**WELWYN HATFIELD BOROUGH COUNCIL
EXECUTIVE DIRECTOR - PLANNING, PUBLIC PROTECTION AND GOVERNANCE**

DELEGATED APPLICATION

Application No: 6/2020/3056/HOUSE
Location: 33 Holme Road Hatfield AL10 9LH
Proposal: Erection of a single storey front extension
Officer: Ms Kirsty Shirley

Recommendation: Granted

Drawing Title :
 PROPOSED
 Ground and First Floor Plans

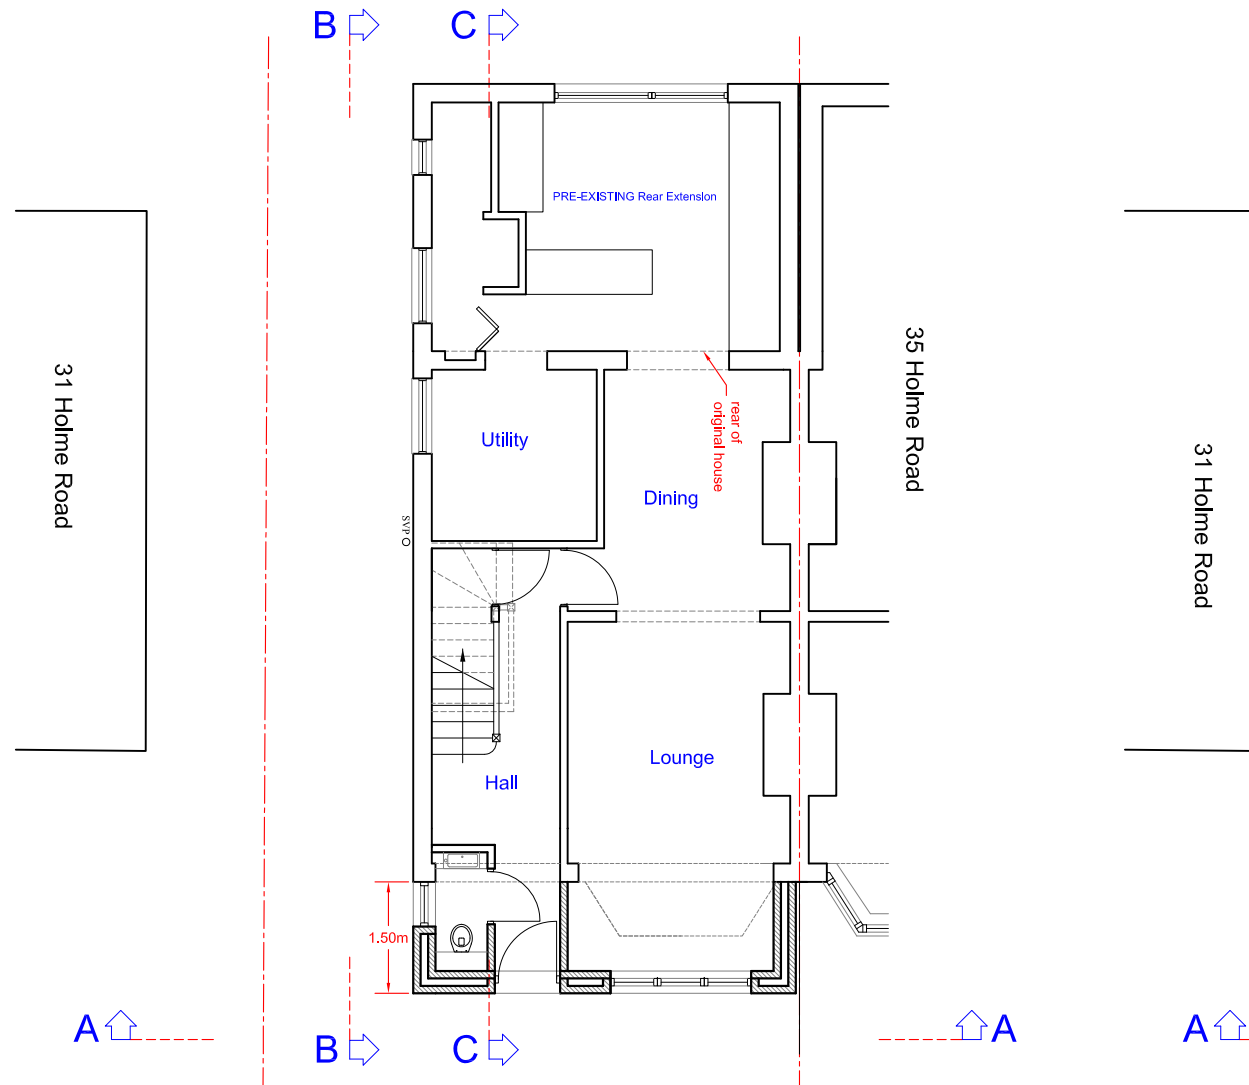
There are no windows inserted into the side elevations of the extension which maintains the privacy of the adjoining neighbours. A forward facing window is inserted into the extension which is smaller in size and scale compared to the existing window, and the substantial spacing remaining between opposite neighbours maintains the privacy of the opposite neighbours.

Comment (if applicable): No additional bedrooms would be created and no additional parking is required. The site benefits from a driveway and on-street parking.

Drawing Title :
PROPOSED
Elevation AA (Front) and Elevation BB (Side)
Section CC

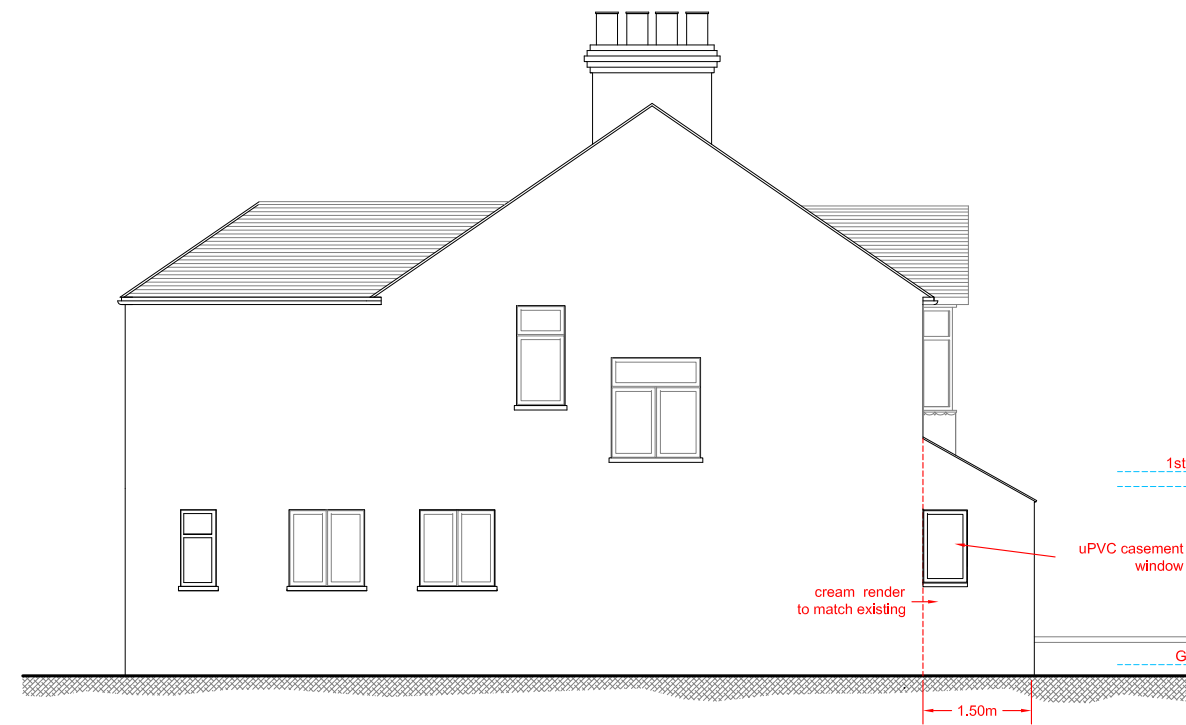
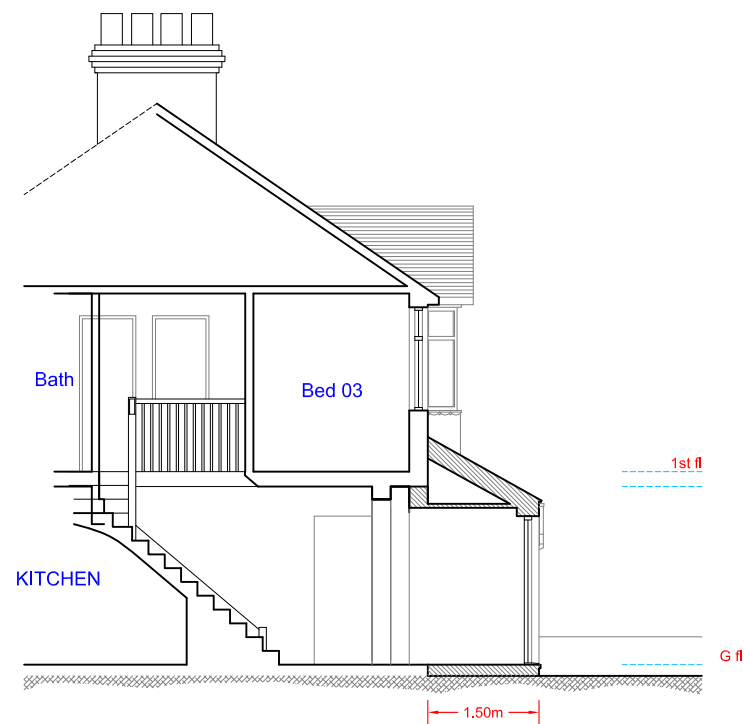
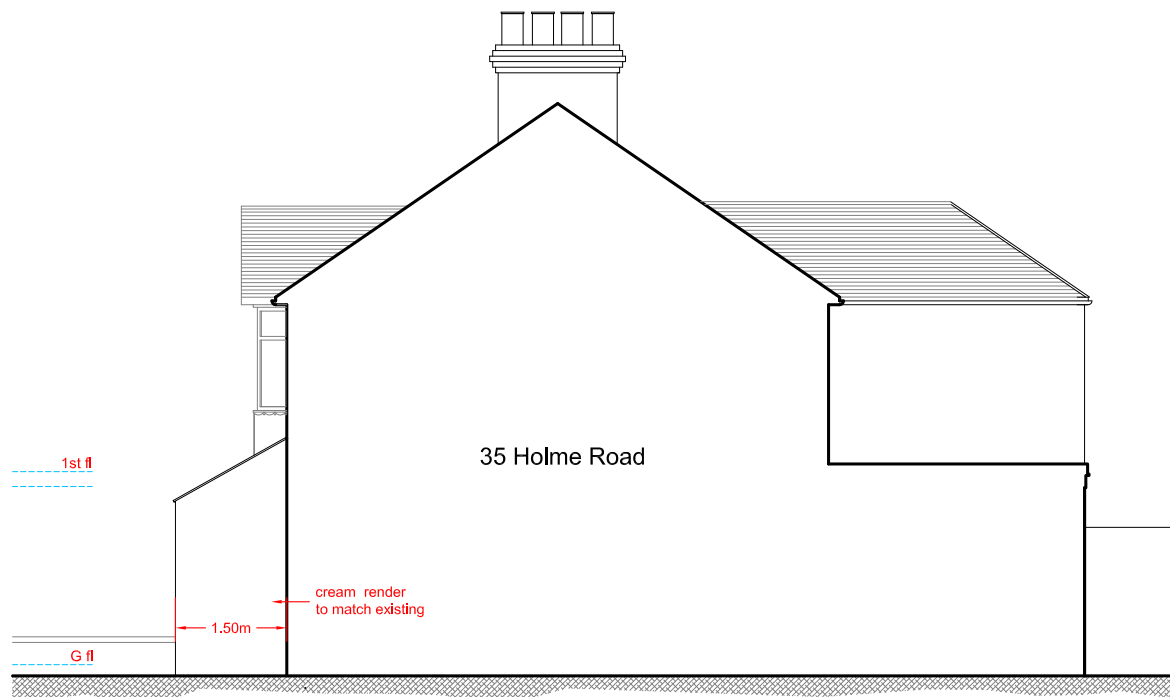
<p>The front elevation of the application dwelling currently features a brick archway which the front door is inset under, and this feature is commonly seen within the street scene. The proposal seeks to erect a single storey front extension across the width of the front elevation to accommodate a new entranceway way, small bathroom and extension to the living room. Projecting front porches are not uncommon in the area and the property adjoining the application features a projecting porch. The extension across the front elevation is not seen within the immediate proximity of the application dwelling, but the extension is subordinate in size and scale, and would not detract from the street scene. The extension features a mono-pitch roof which is in keeping with the gabled roof of the dwelling, and a window is inserted into the front elevation which is in keeping with the existing windows. Matching materials are proposed and this can be secured by condition.</p> <p>Subject to the suggested condition regarding materials, it is considered that the proposed development would be acceptable in terms of its appearance and would maintain the character of the area. In this respect, no objections are raised with regard to District Plan Policies D1, D2; the SDG; and the NPPF.</p>

Given the limited depth and height of the extension, would not appear visually overbearing or unduly dominant when viewed from neighbouring the properties, nor would it result in harmful loss of sunlight/daylight.

1. The roof tile, mortar, windows, detailing, guttering, soffits and other external decorations of the approved extension/alterations must match the existing dwelling/building in relation to colour and texture.
